Current Zoning: NS (neighborhood services)
Proposed Zoning: I-2(CD) (general industrial, conditional)

Approximately 9.84 acres located on the south side of Old Dowd Road at the intersection with Sam Wilson Road.

The petition proposes to allow 92,000 square feet of gross floor area of indoor self-storage as well as outdoor boat and RV parking and storage.

PLANNING STAFF REVIEW

**CONCEPT PLAN - L-2**

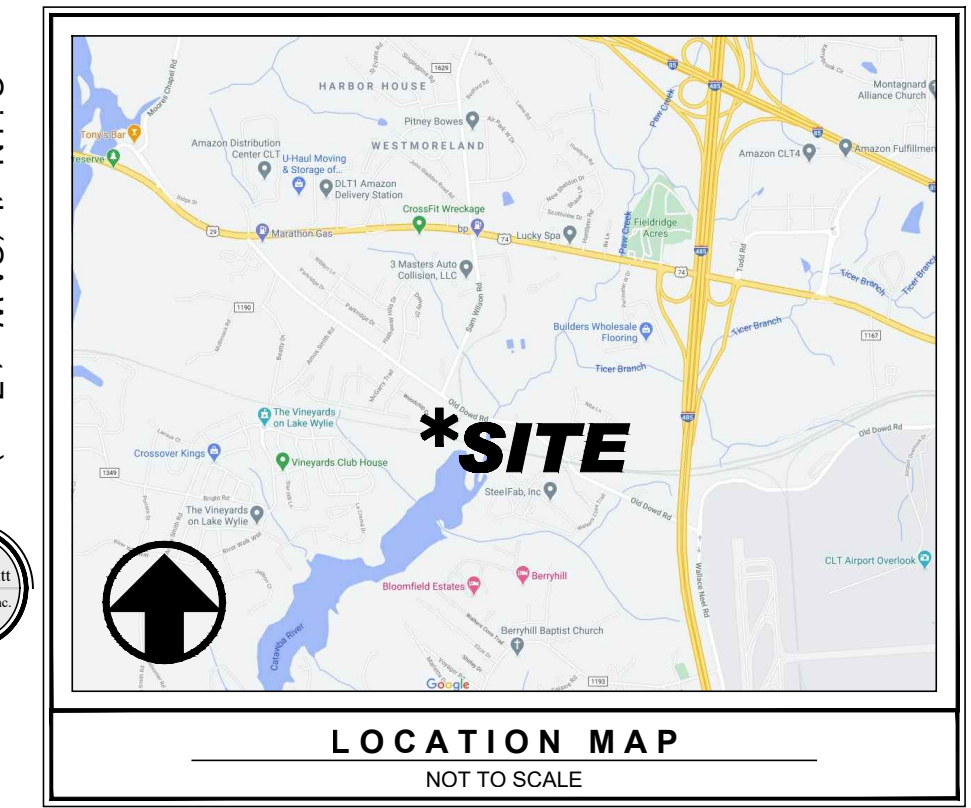
- ~~1. Revise the site plan to show a 6' sidewalk as is referenced in the conditional notes.~~ **ADDRESSED**
- ~~2. Add a conditional note to commit to connecting the traffic signal to the CDOT network via fiber optic connection.~~ **ADDRESSED**

- ~~4. Revise southbound approach laneage to thru right lane with dedicated left turn lane. If the lane configuration remains right lane with thru left the proposed driveway stem needs to match so the signal can run without split phase operation.~~ **ADDRESSED**

- ~~5. Add a conditional note committing to the right turn lane on Old Dowd Road shown on the site plan.~~ **ADDRESSED**
- ~~6. Extend the driveway stem into the site as is shown in CDOT's memo.~~ **ADDRESSED**

- ~~7. Please include the following note under Environmental Features: "Development within any SWIM/PCSO Buffer shall be coordinated with and subject to approval by Charlotte-Mecklenburg Storm Water Services and mitigated if required by City ordinance. Petitioner acknowledges intermittent/perennial stream delineation reports are subject to review and approval upon submission of development plans for permitting and are not approved with rezoning decisions. The existing pond on site may require a buffer depending on results of the delineation report."~~ **ADDRESSED**
- ~~8. Revise the buffer on the western property boundary to be a minimum of 100', which can be reduced to 75' with a berm.~~ **ADDRESSED**
